As requested, the following provides responses to ExA questions directed to IP's

LV.2.2 – Landscape and Visual. The plans which form Appendix LV.2 Trees to be Removed and Replaced at Coronation Avenue WQ LV.1.8 [REP1-044] are annotated 'Draft'. The Applicant is asked to explain how this relates to the requirement in R5(3) of the dDCO for the landscaping scheme to include a strategy for the replacement of trees which are to be removed at Coronation Avenue? IPs are asked to comment on the proposals for Coronation Avenue.

Revision: P02

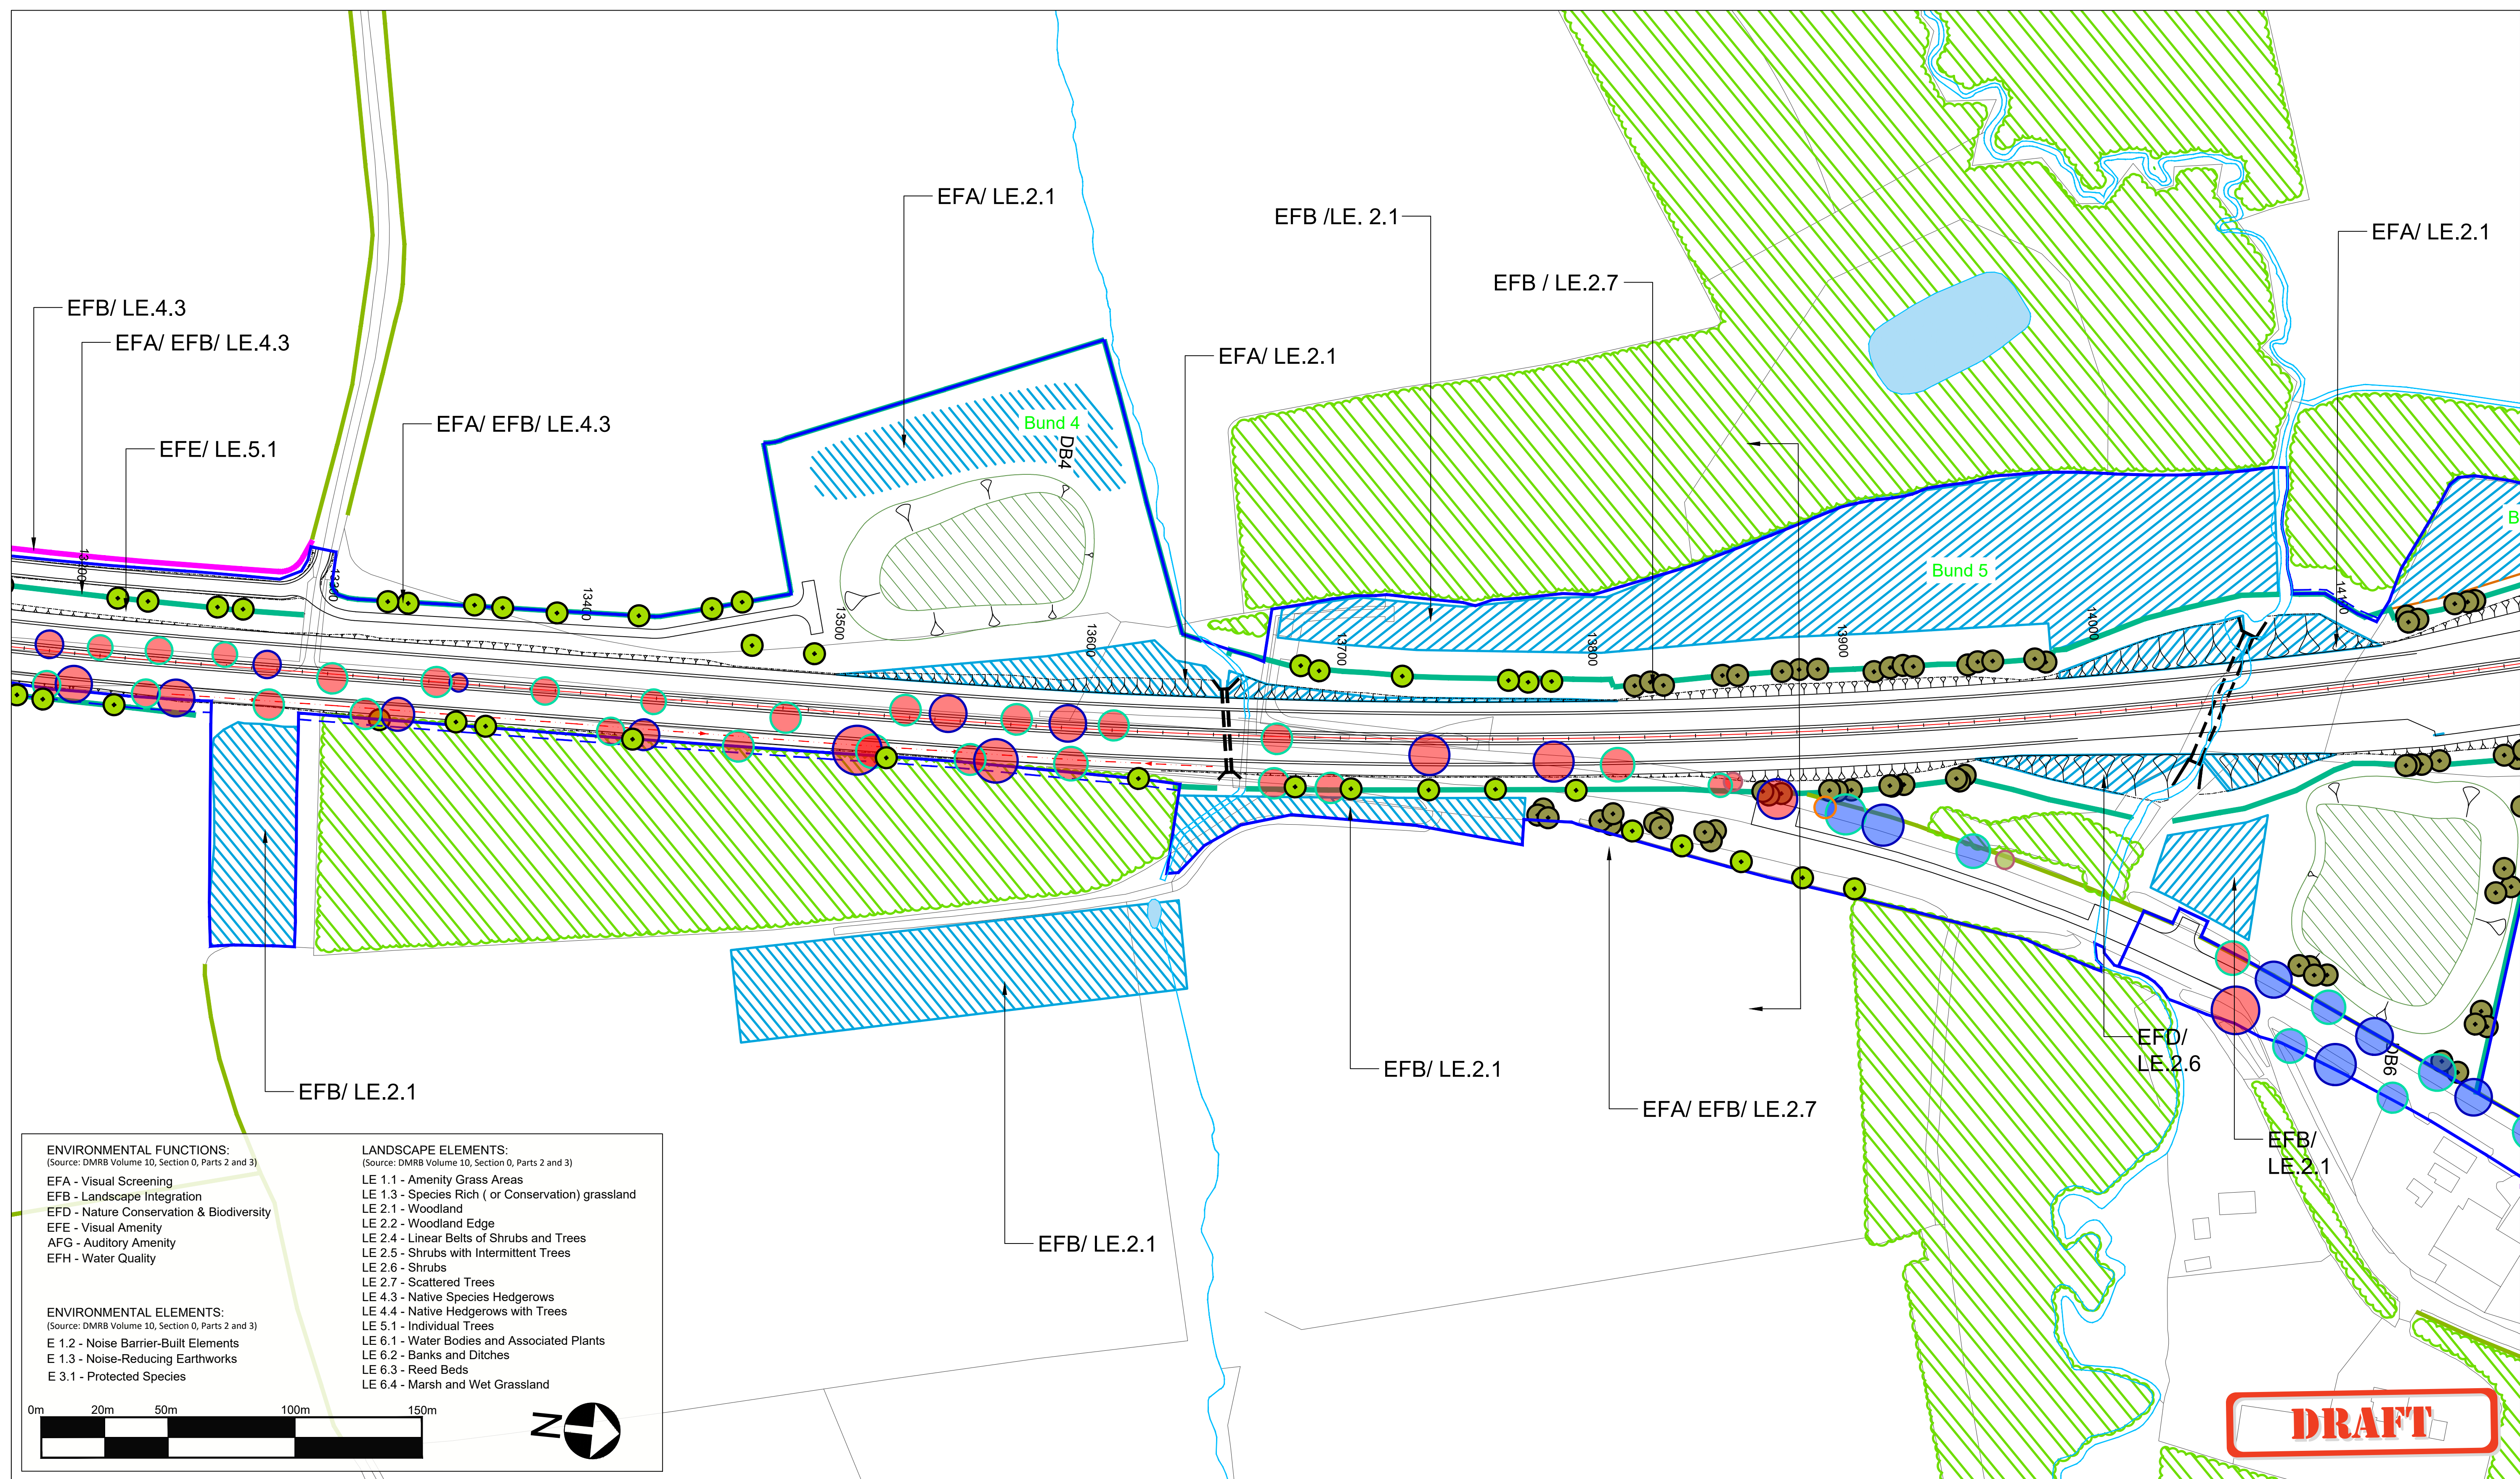
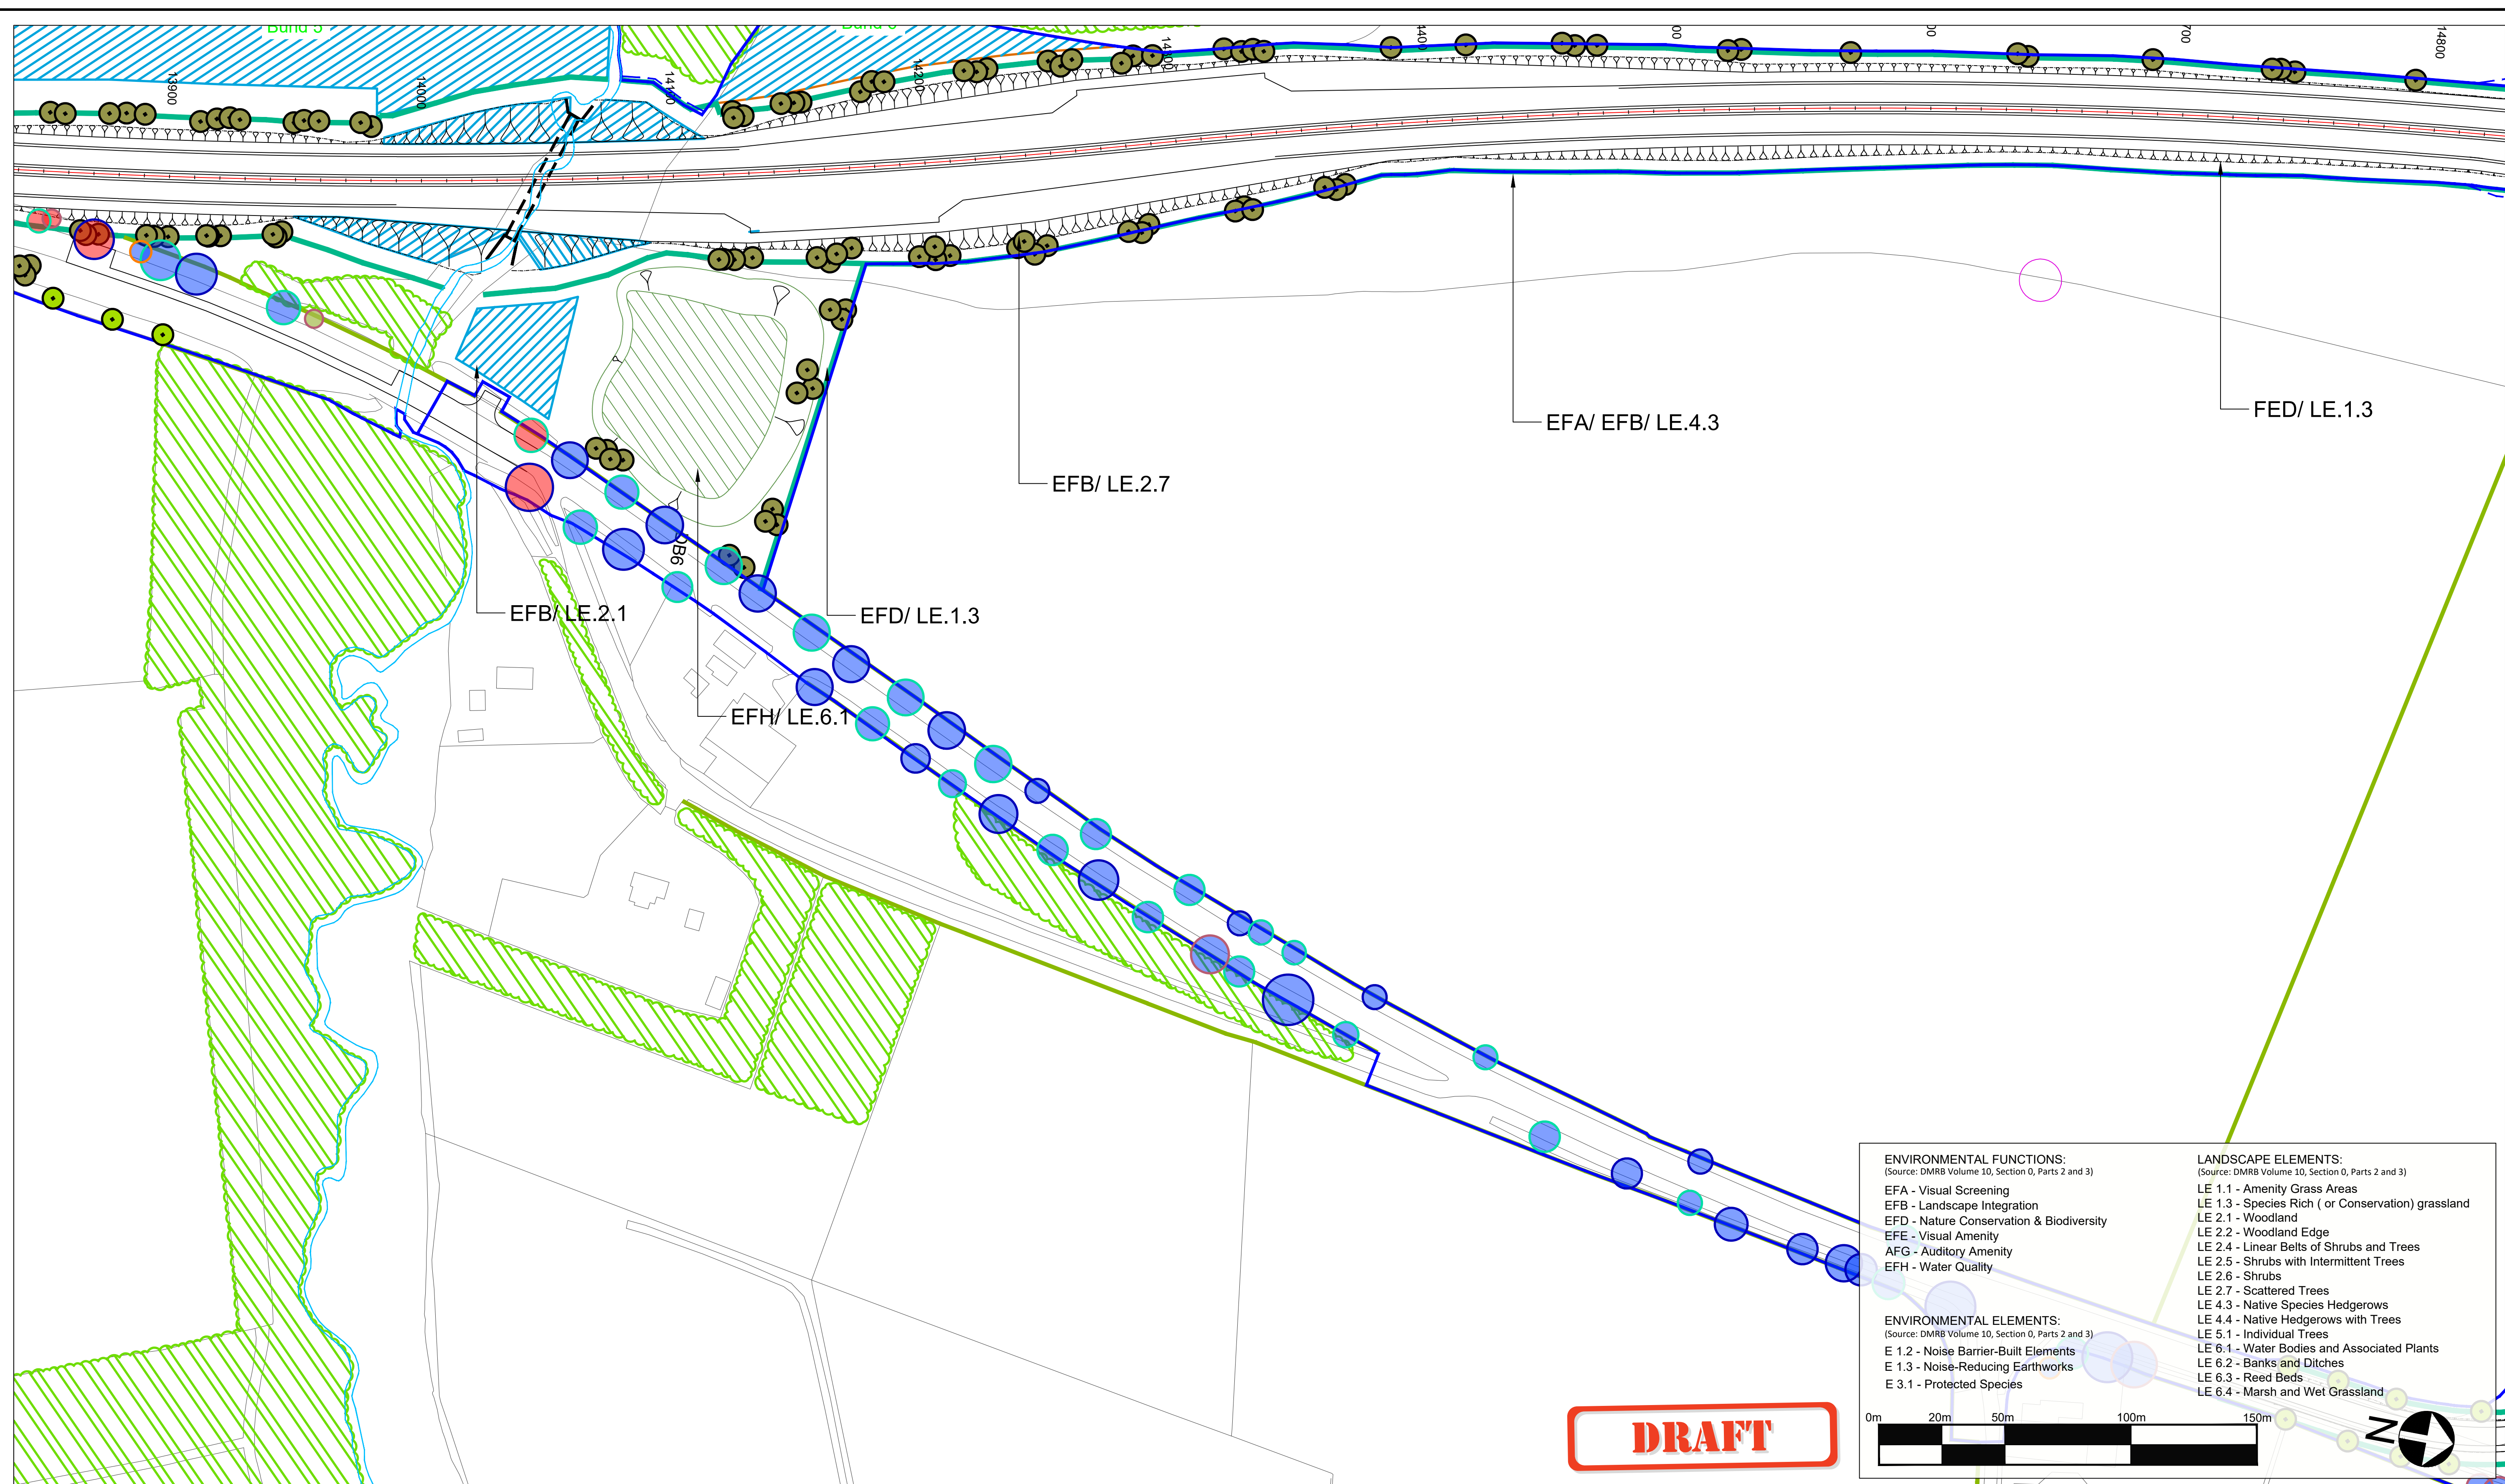
1. In reviewing this documentation again, I remain disappointed by the scale of tree loss inflicted by the scheme. Undoubtedly the biggest impact is on the distinguished Coronation Avenue of trees which line both sides of the single carriageway. I am not aware of any other A classed road in the country which can boast such an extensive configuration of mature trees, which are now approaching 70 years age. The main source of frustration stems from an underlying belief that more could have been done to protect the trees and improve the levels of mitigation. For example, most of the work carried out on the existing road is asymmetric which means that the eastern edge of the road has been spared some of the major works. Unfortunately, this does not appear to have provided any extra protection to the trees on the eastern edge.

2. In total it appears that circa 200 coronation trees are to be felled and replaced with young trees which I understand will take a minimum of 15 years to mature. Even then the visual impact and environmental contribution will remain well short of what we enjoy today.

3. In looking at the plans for the new arrangement of replacement trees the Avenue effect would appear to have been lost. The configuration of the trees is no longer linear and there are too many gaps in the flow to emulate the Avenue effect. Furthermore, the distances between the trees flanking each side of the road are over 50 metres in some cases.
